Department of Planning and Environment

Our ref: DOC21/1116395
Senders ref: SSD- 17161650

Subject: Response to Environmental Impact Statement for Horsley Drive Business Park Stage 2, Buildings 2 and 3 (SSD- 17161650)

Figure 4.7 Flood Depth Output - PMF, Post Developed

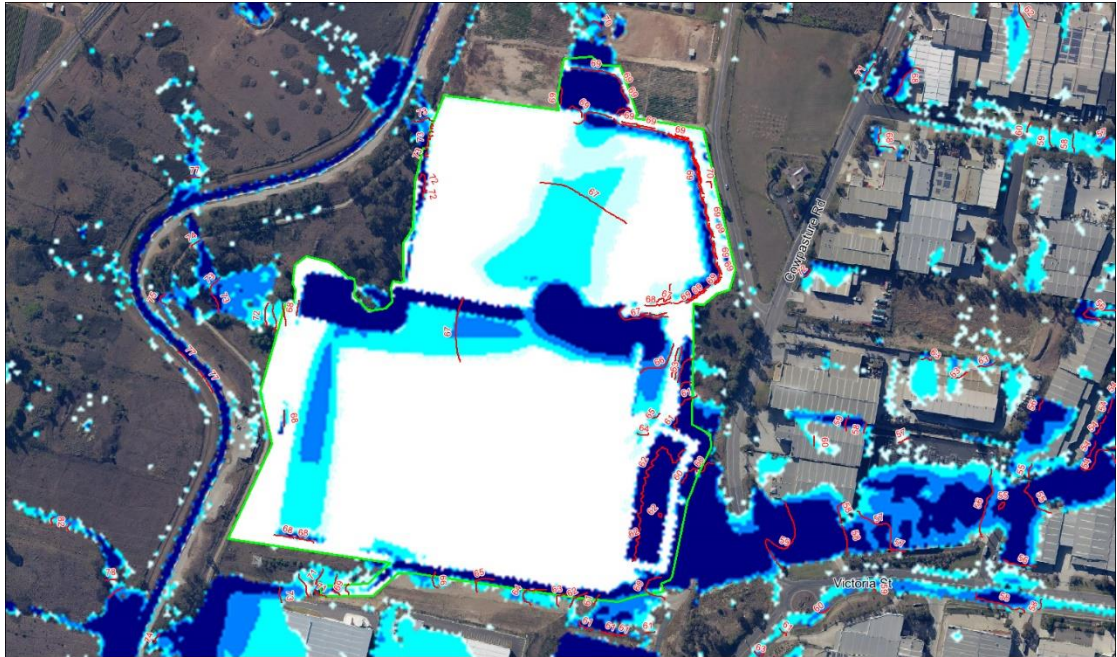
expected to be impacted under the PMF event with a floodwater depth of 0.3m with exit routes from the site likely to be interrupted due to a floodwater depth of 1m and higher.

The flooding risks under the PMF event can be addressed and mitigated for the proposed development through site specific provisions including emergency management procedures and facilities along with shelter-in-place options since the duration of the PMF event would be around two hours. The submitted Civil Engineering Report (Costin Roe, September 2021) has outlined these risks briefly, which need to be elaborated and integrated in the design, construction and operational stages of the development.

EES does not have any specific concerns subject to the development and implementation of risk management plans, as outlined above, for addressing and mitigating flooding risks under the PMF event at the site.
